CITY OF PORTLAND, MAINE

February 3rd, 2014

Project Name: "118 on Munjoy Hill" Condominium
12 unit residential, and 2 unit commercial, condominium
Project ID: #2013-255
Project Address: 118 Congress Street
CBL: 16-D-2
Applicant: Ed Theriault, EMT, LLC (118 Condominiums, LLC)
Planner: Jean Fraser

On January 28th, 2014 the Portland Planning Board considered and approved a Level III Final Site Plan and Subdivision proposal for the construction of a 4-story 14 unit condominium building at 118 Congress Street, comprising 2 commercial units totaling approximately 1800sq ft floor area, 18 parking spaces on the ground floor to the rear of the commercial units, and 12 residential units above.

6  
L2.0  
NOT TO SCALE  
RAISED GRANITE PLANTER - PLAN VIEW

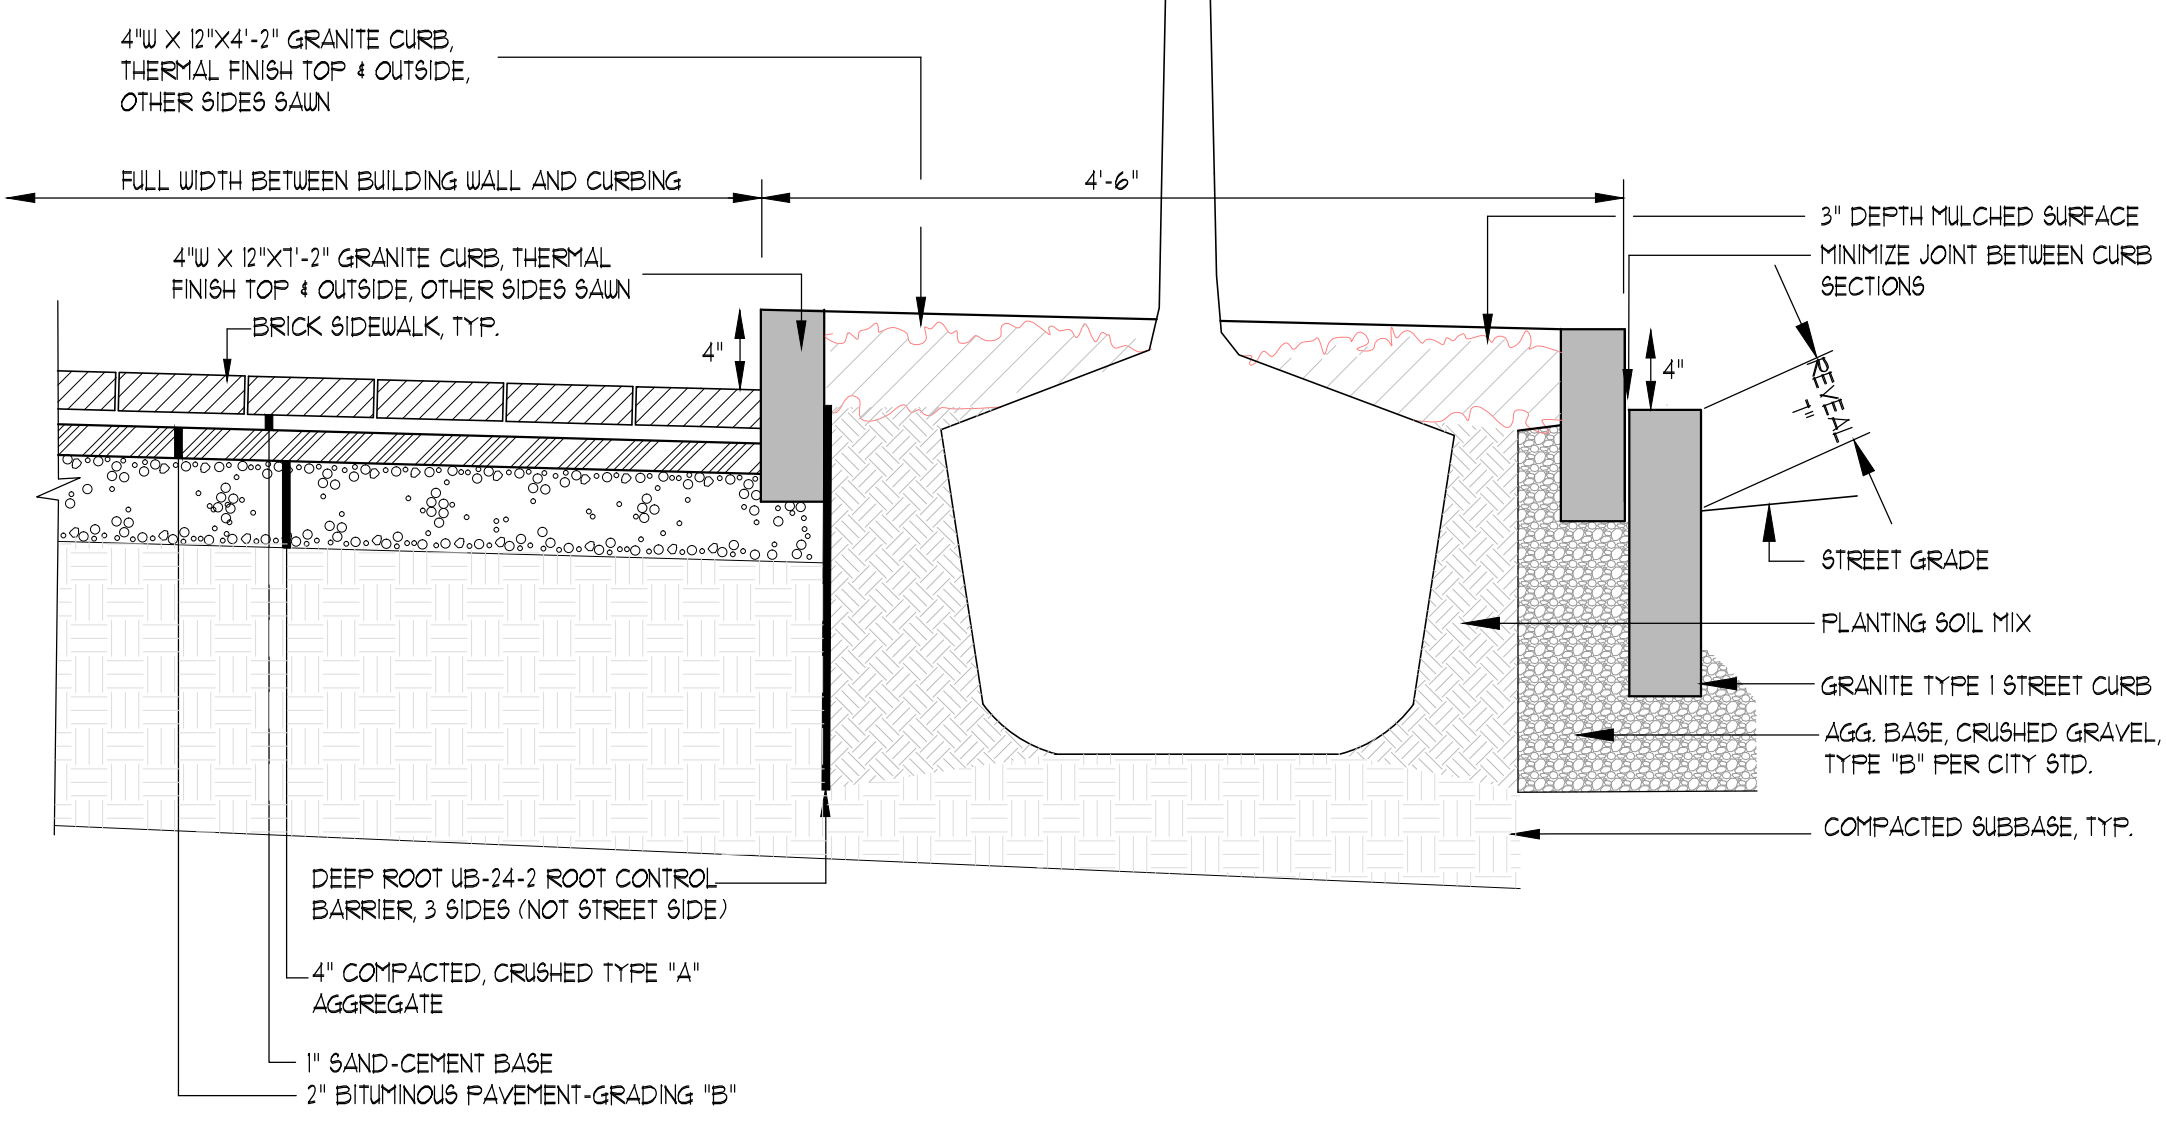
Granite planters in right of way - the six granite planters are proposed to be planted with street-trees and 'Cranesbill', perennial geranium. This will add interest to the typical mulched tree well. Long term however it is unlikely the city would be able to maintain these plantings. Ideally, the project could adopt the tree wells and maintain the landscape planting.
